## **Response to Planning application from Hertfordshire County Council (T and CP GDP Order 2015)**

**District ref:** 6/2017/2105/RM

Plot 4100 Gypsy Moth Avenue  
Hatfield Business Park  
Hatfield

Approval of reserved matters (access, appearance, landscaping, layout and scale) for the erection of two motor retail showrooms and valet building with associated parking and landscaping of the approved outline planning permission 6/2015/2043/OUTLINE, dated 05/07/2017

Drawing title	Status, Drawing number & revision	Amendments
Proposed Site Plan	3280/ 030 M	Planning - Material Amendments
Drawn by	Checked by	A1 Scale
EM	JA	As indicated
		A3 Scale
		Date
		14/06/2018
		14:31:20
		Status
		PLANNING

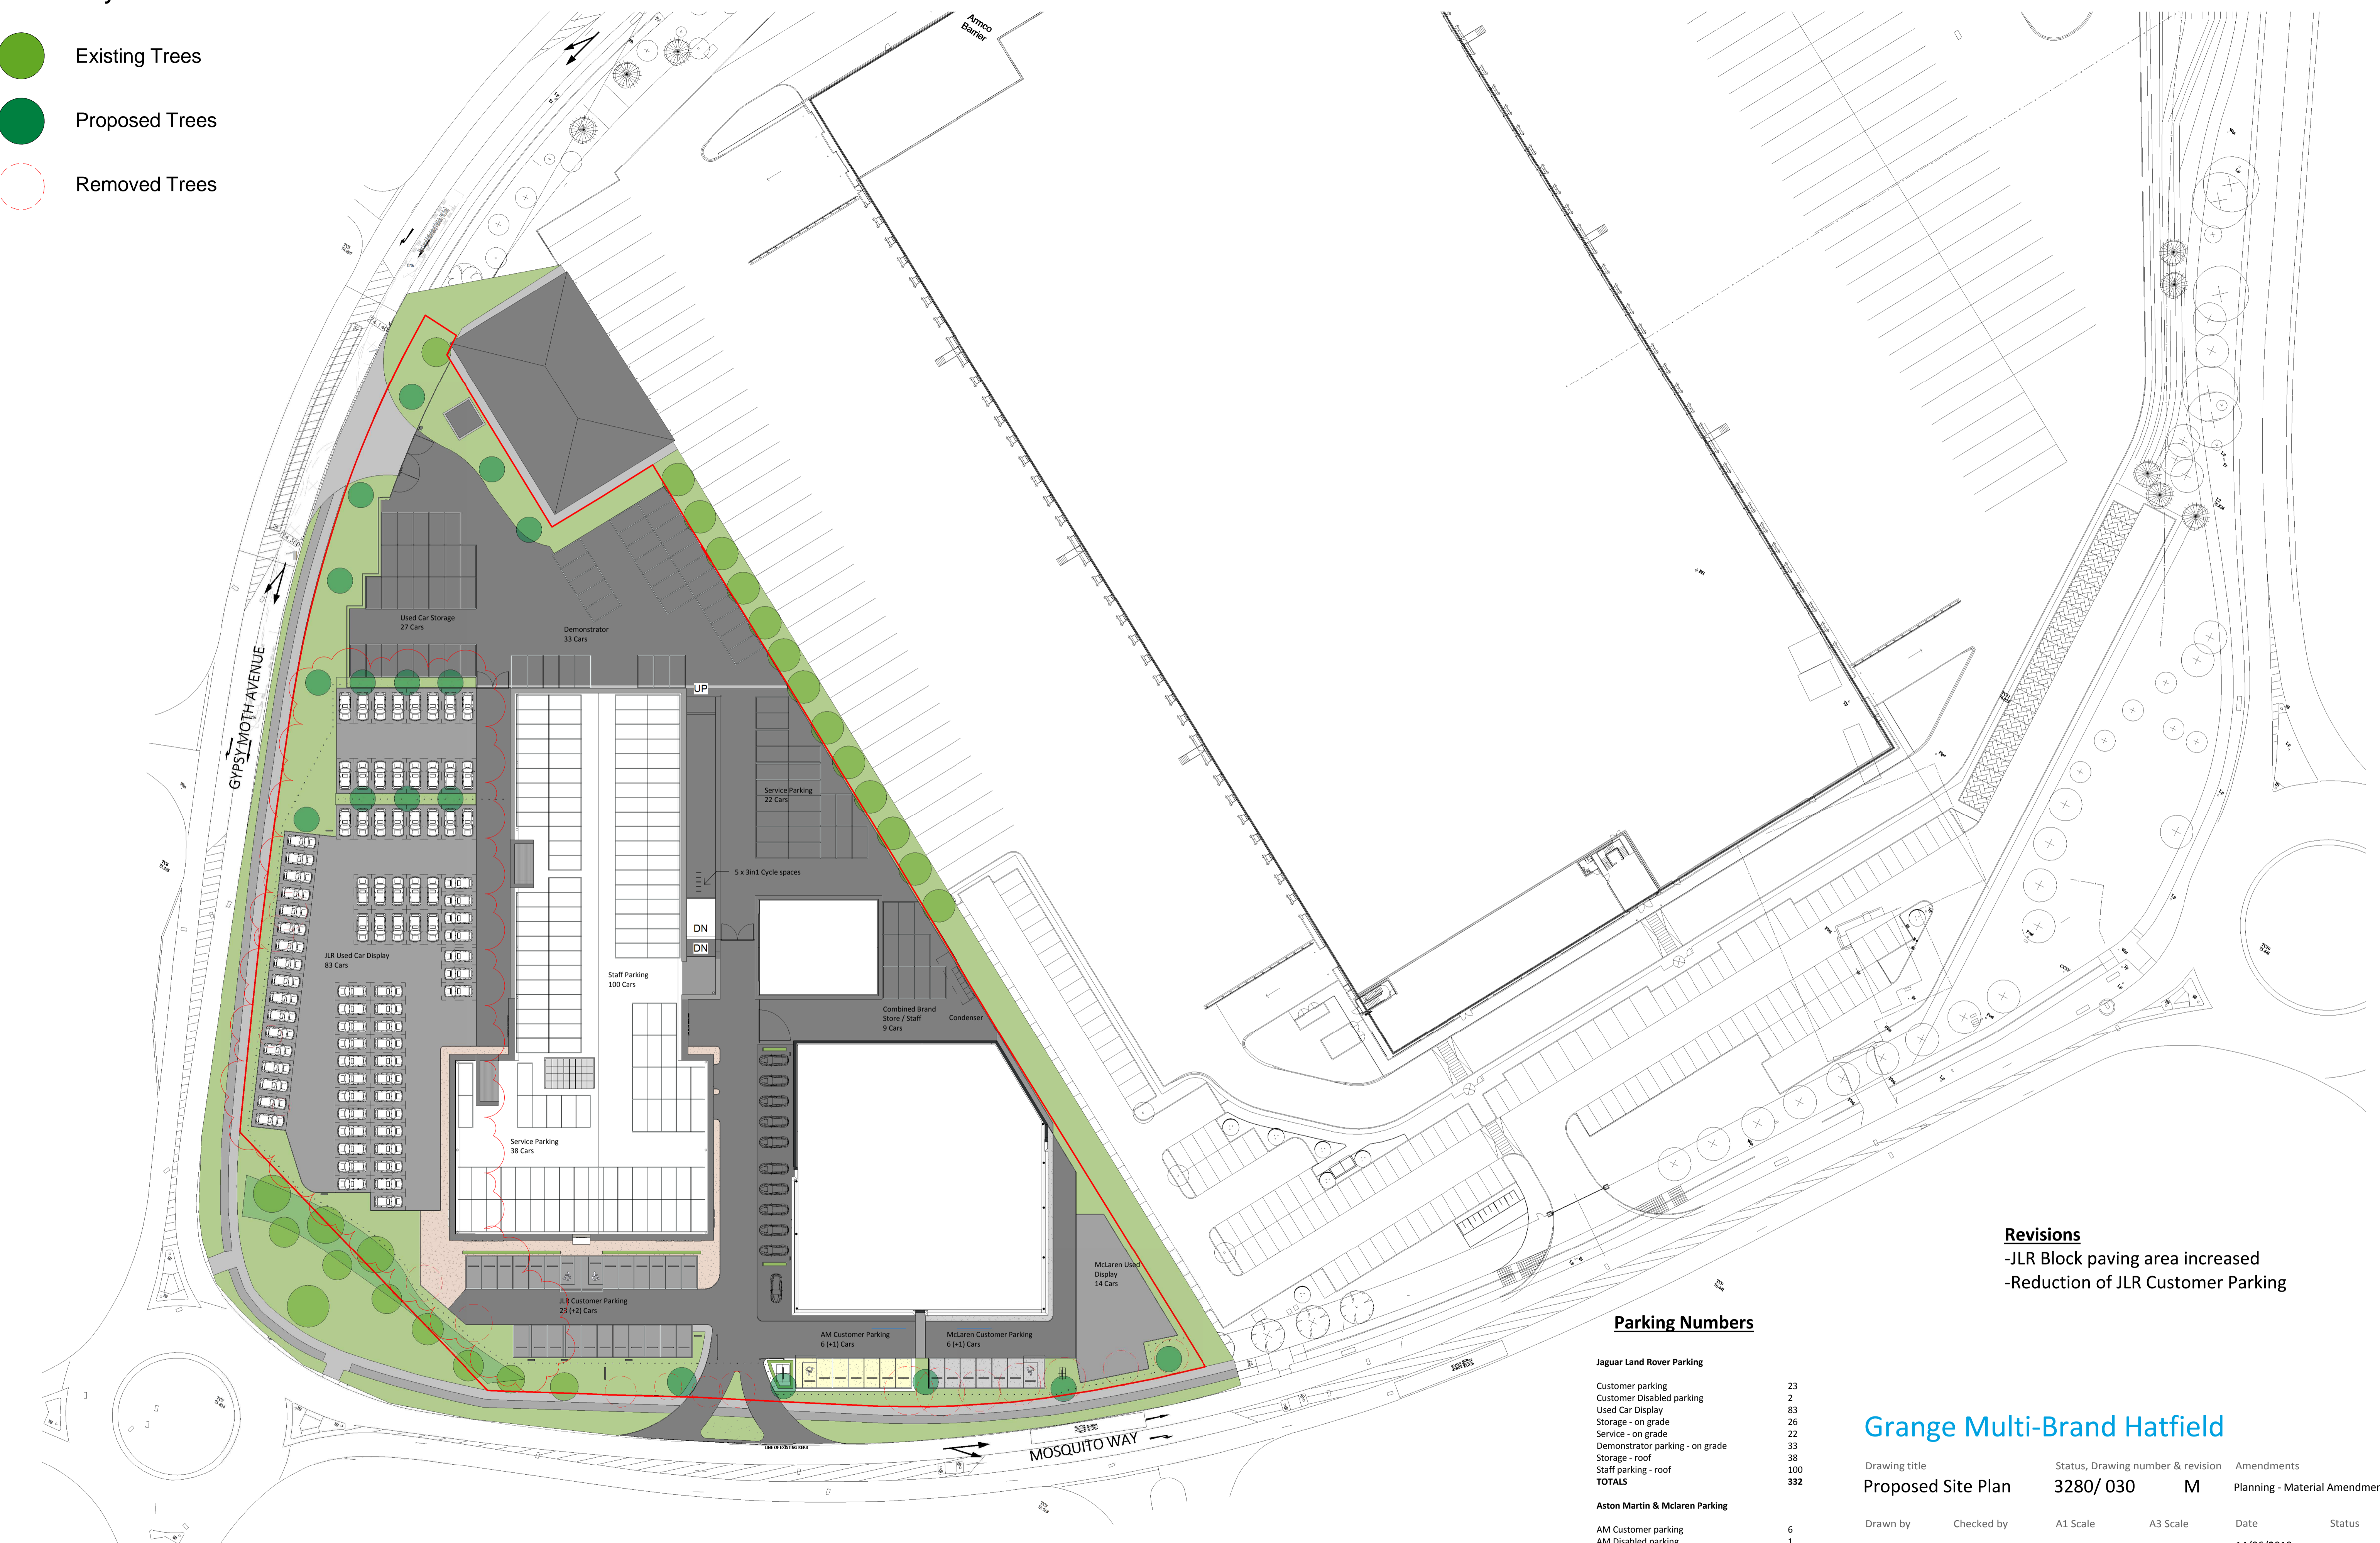
The applicant submits, in respect of reserved matters, revised site layout (Proposed Site Plan 3280/ 030). The accesses, as shown, respect that agreed in principle at Outline.

Drawing 3280 / 030 appears to have some detail in respect of swept paths of large vehicles (shown adjacent to the existing access on Gypsy Moth Avenue) however this swept path information is not visible beyond the extent of the carriageway, and therefore fails to demonstrate that the gate alignment and internal route configuration is appropriate to enable access for larger vehicles. It has previously been observed that the formation of access on Mosquito Way will necessitate the relocation of bus cage, and whilst drawing 3280/030 does provide details of a proposed solution in this matter, it shall require vehicles overtaking a stationary vehicle using the dedicated right hand turn lane, such a situation occurs to the north of Gypsy Moth Lane without evidence that it has resulted in problems. It is considered all such matters would be expected to be dealt with in respect of discharging condition 5 of the outline consent The Highway Authority has responded separately to this (district reference 6/2017/2625/COND), and submitted details do not address this point.
